MEMORANDUM

DATE: March 28, 2022

SUBJECT: **On-Call Contract #17-067H-1; PO # 8115428**
Traffic Impact Study Reviews
Task Order #2: Grand Reserve Phase I TIA Review

Figure 2b
Intersection Spacing
 Grandview Reserve Phase 1 (LSC #S214240)

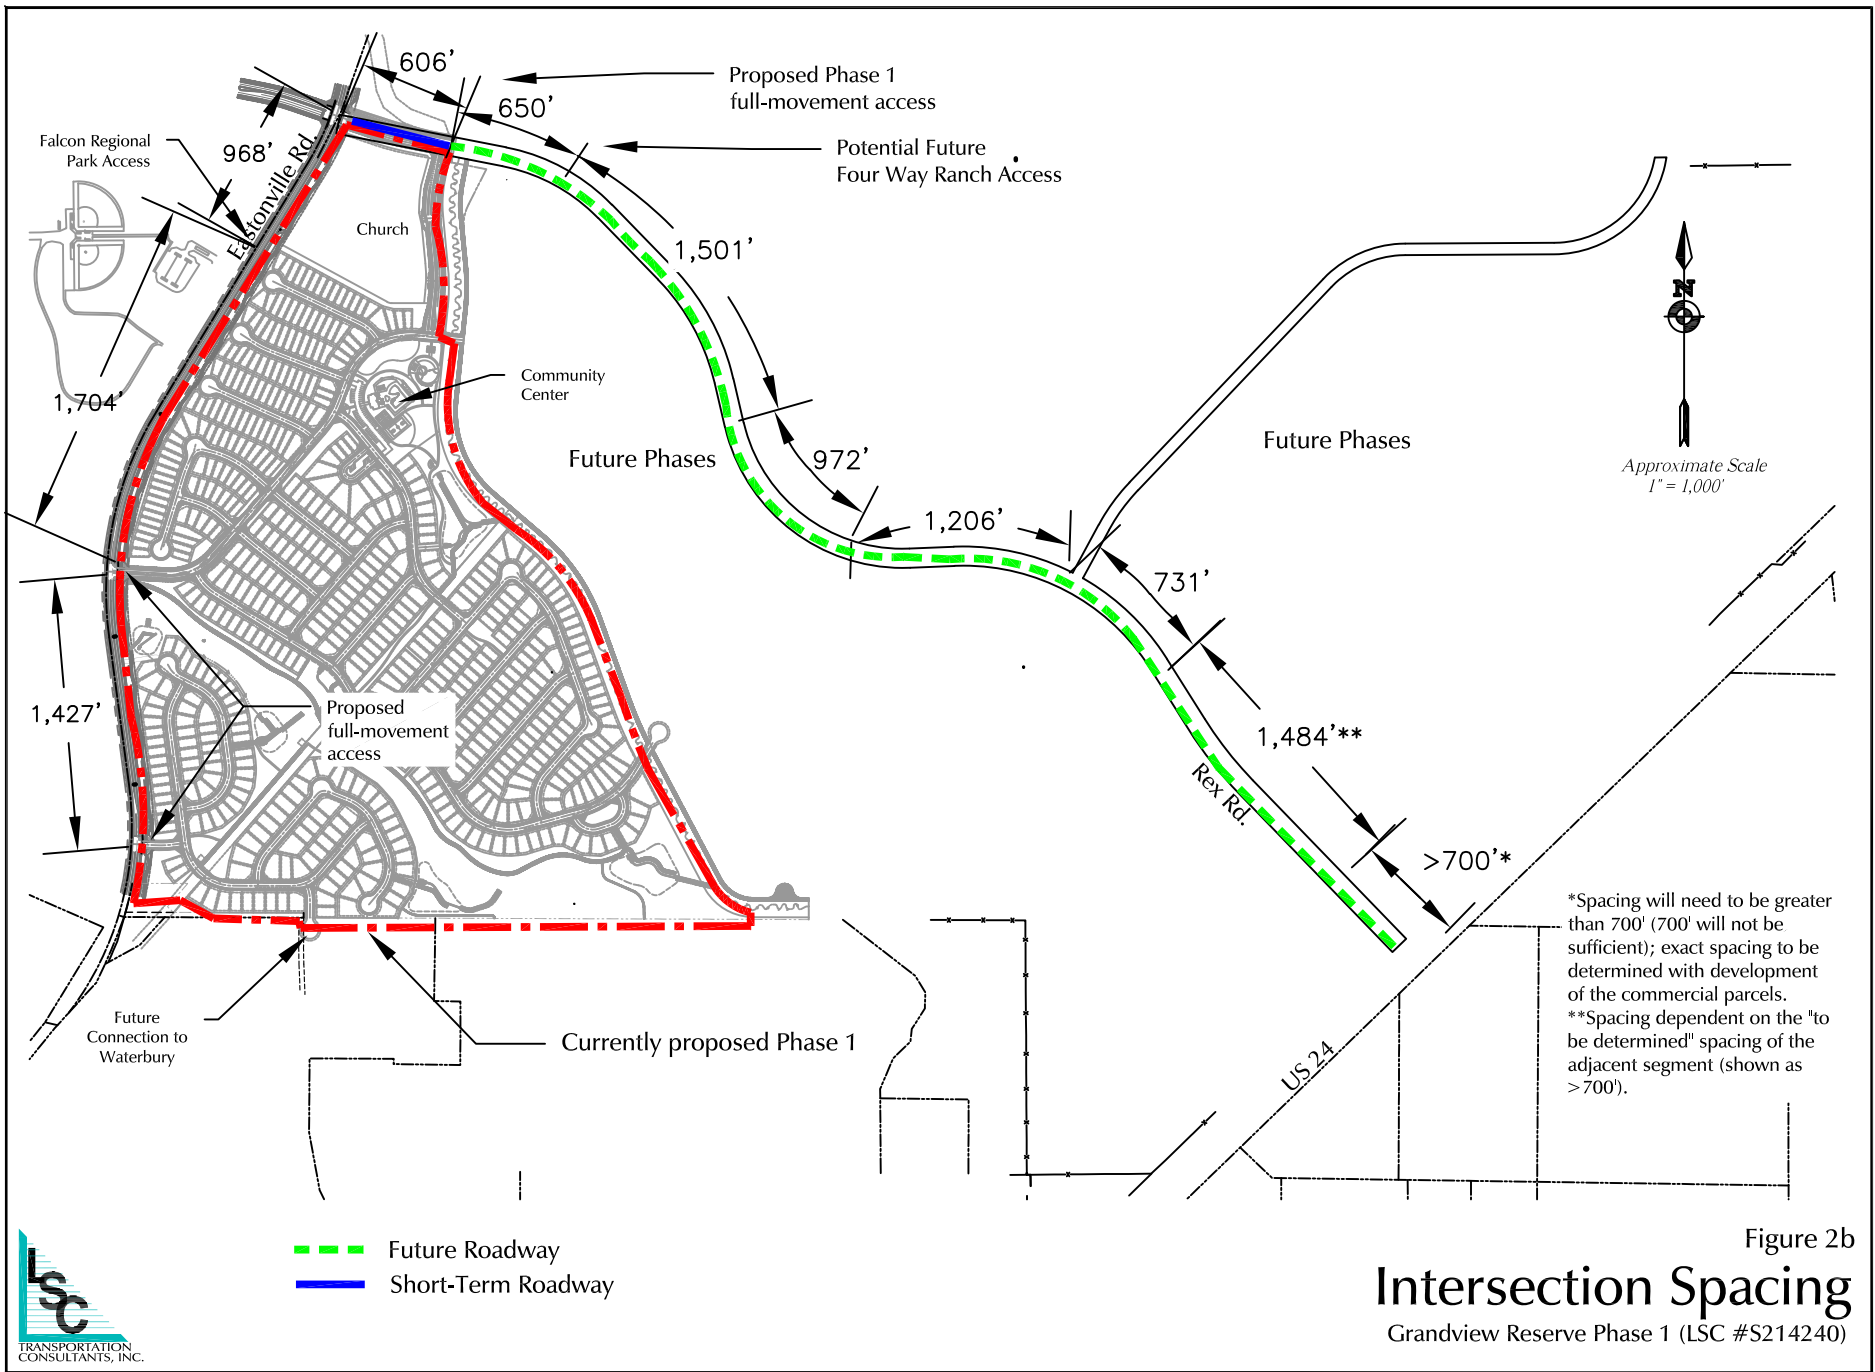
5. Access spacing along Eastonville Road (Figure 2b) ignores the existing Falcon Regional Park and the potential church access. Please update the access analysis to reflect these access points.
